Application for a non-material amendment following a grant of planning permission.

DEMOLISH SINGLE STOREY BUILDING, EXTENSION &
REFURBISHMENT TO CREATE PRIMARY CARE
RESOURCE CENTRE.

H16 - 0112 - 10

RAISE HEIGHT OF WALL TO REAR OF NEW EXTENSION
AND FOR TROUSING TO ACCOMMODATE NEW LIFT.

Spalding Medical Centre
Proposed Elevations

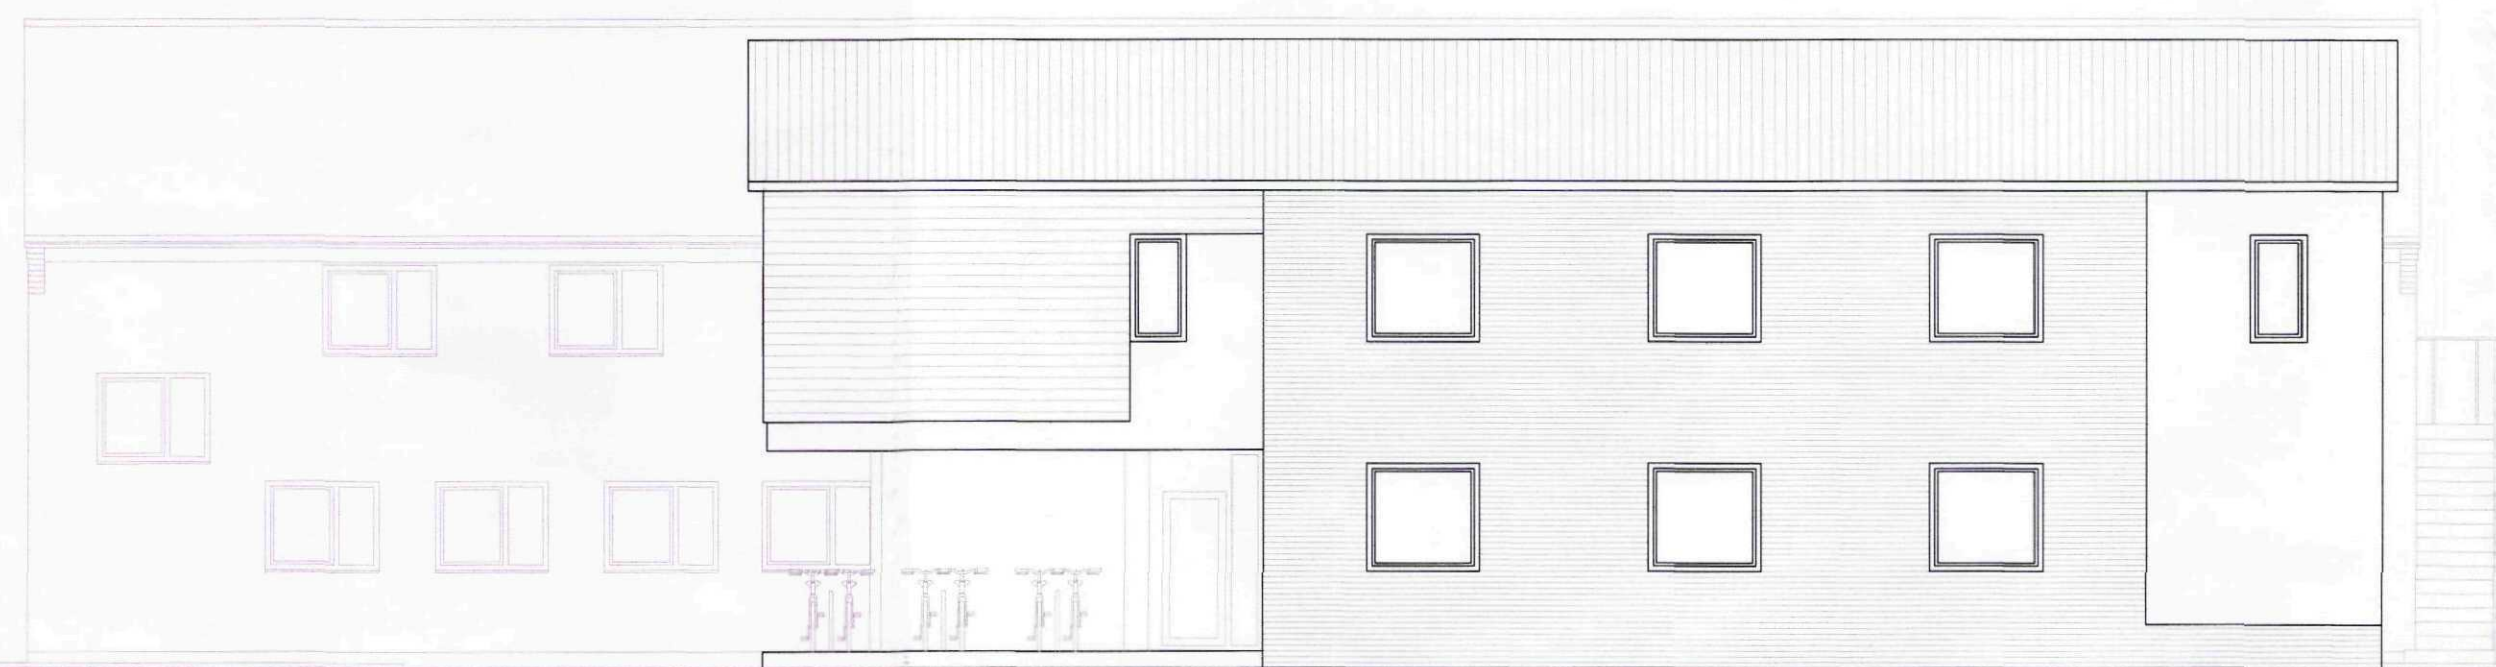
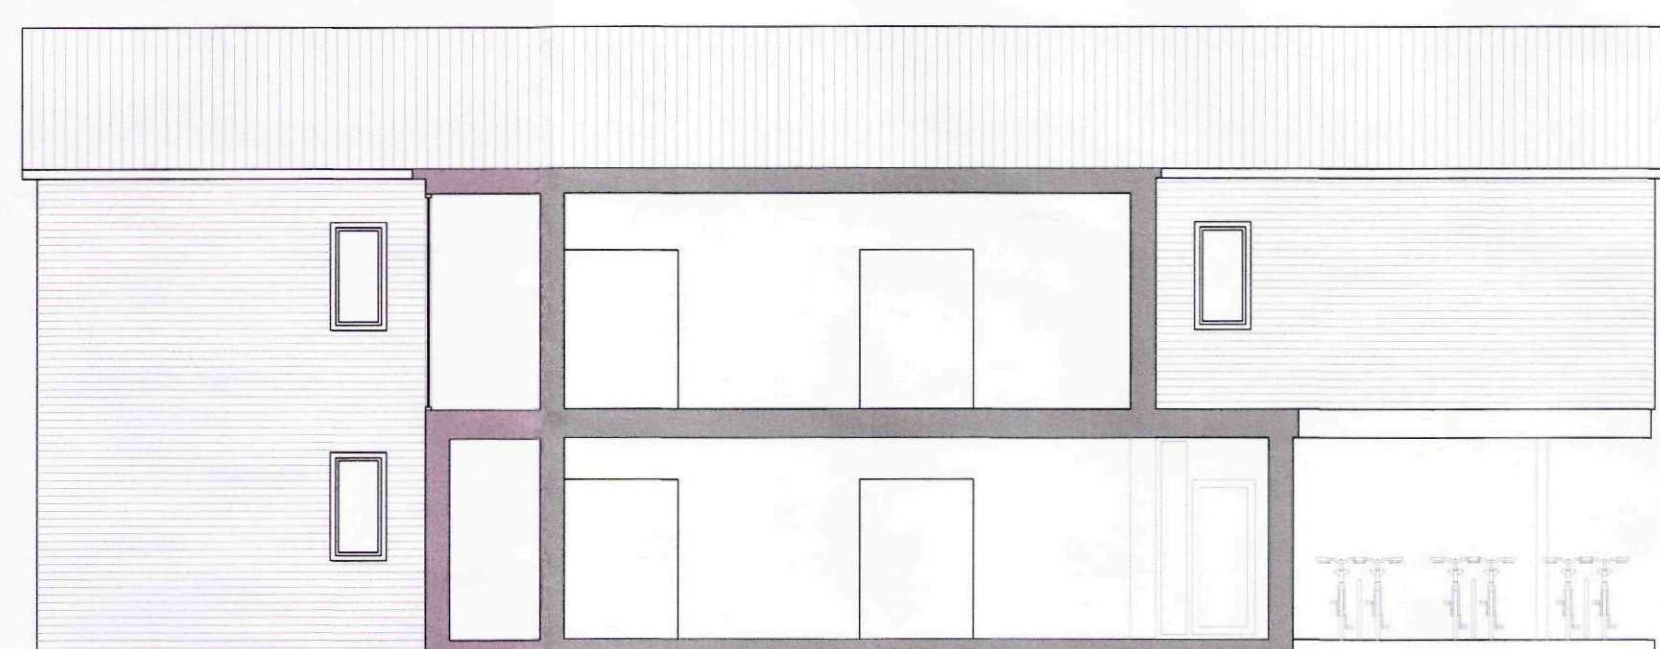
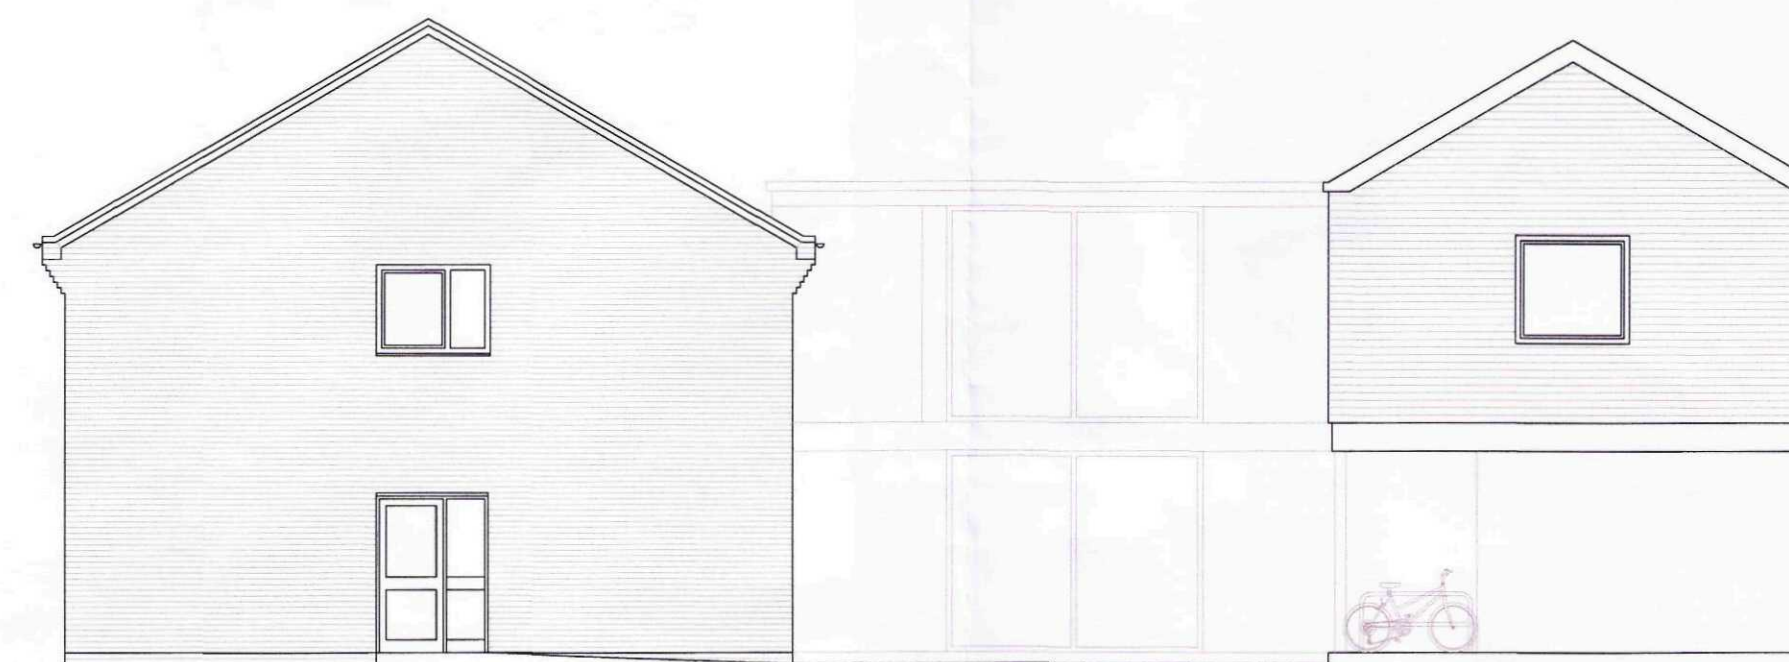
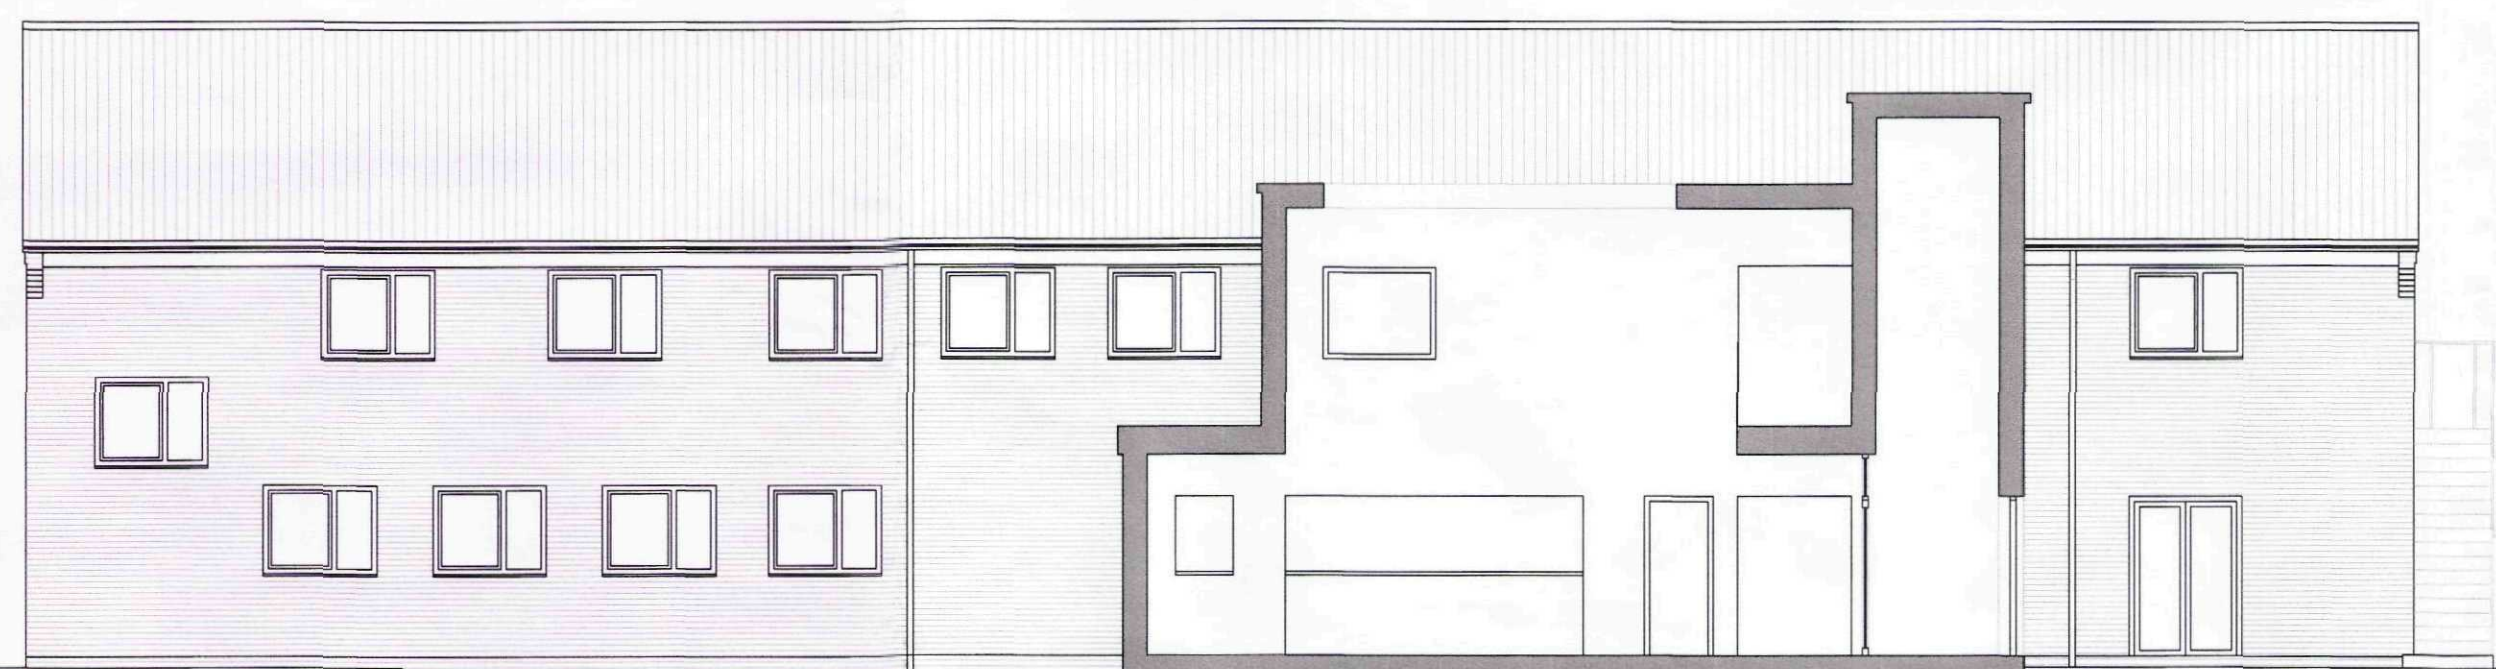
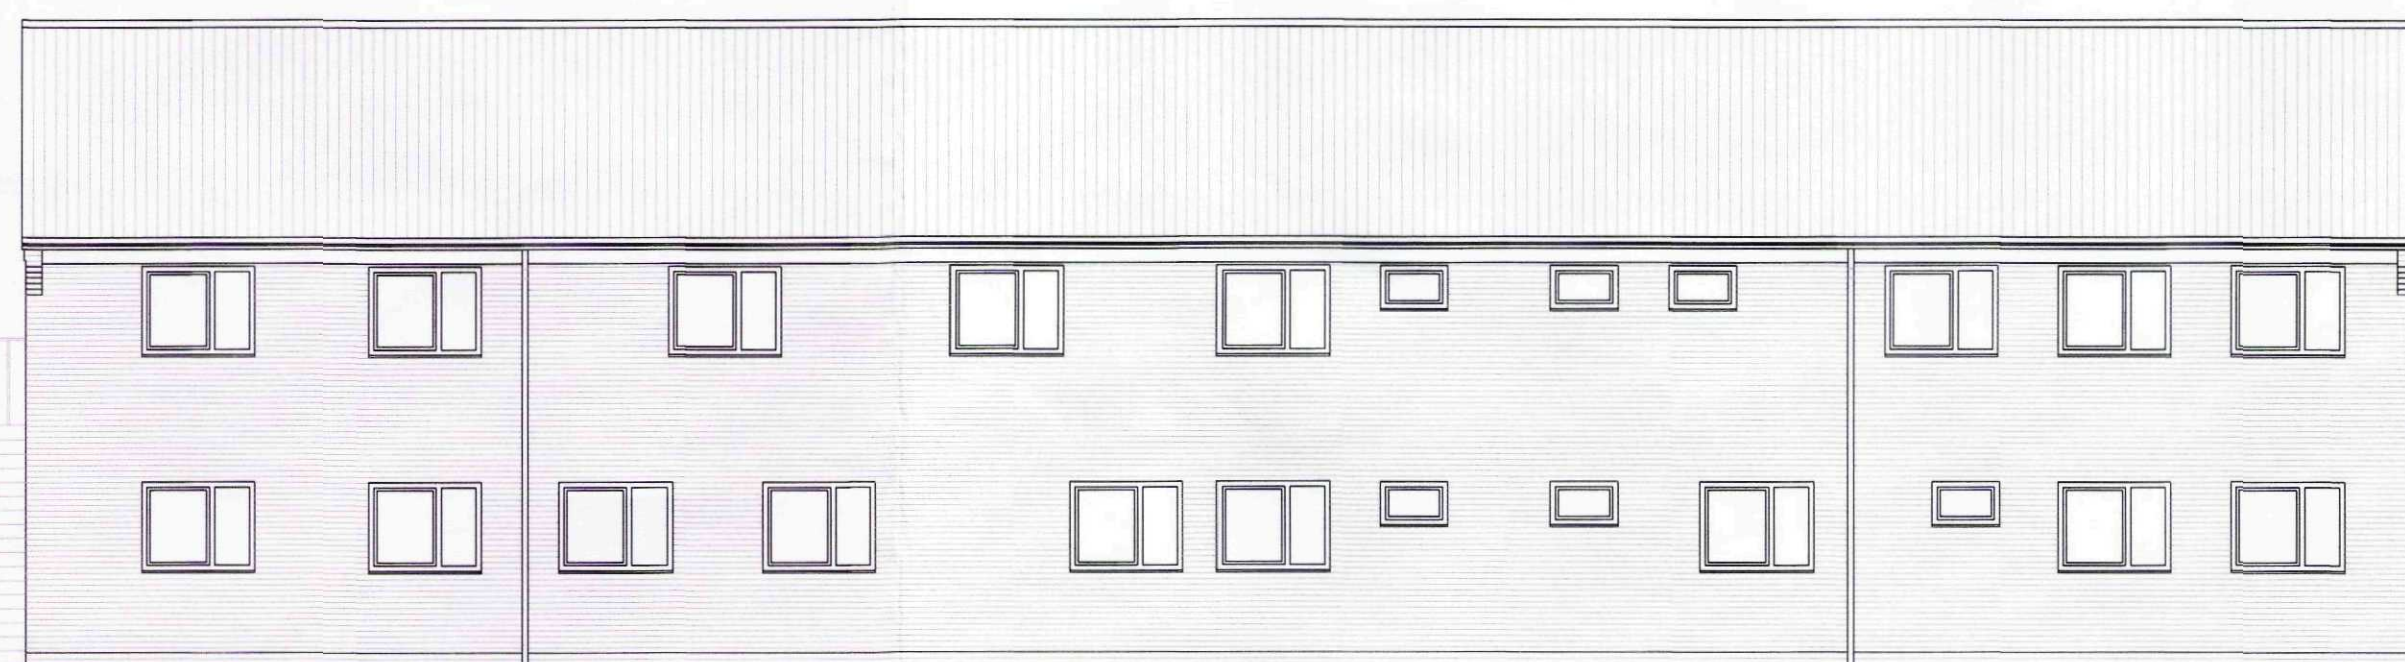
FOLLOWING DETAIL DESIGN TUCKED ROOM FOR NEW LIFT
REQUIRES RAISING.

CO9-105-05B.
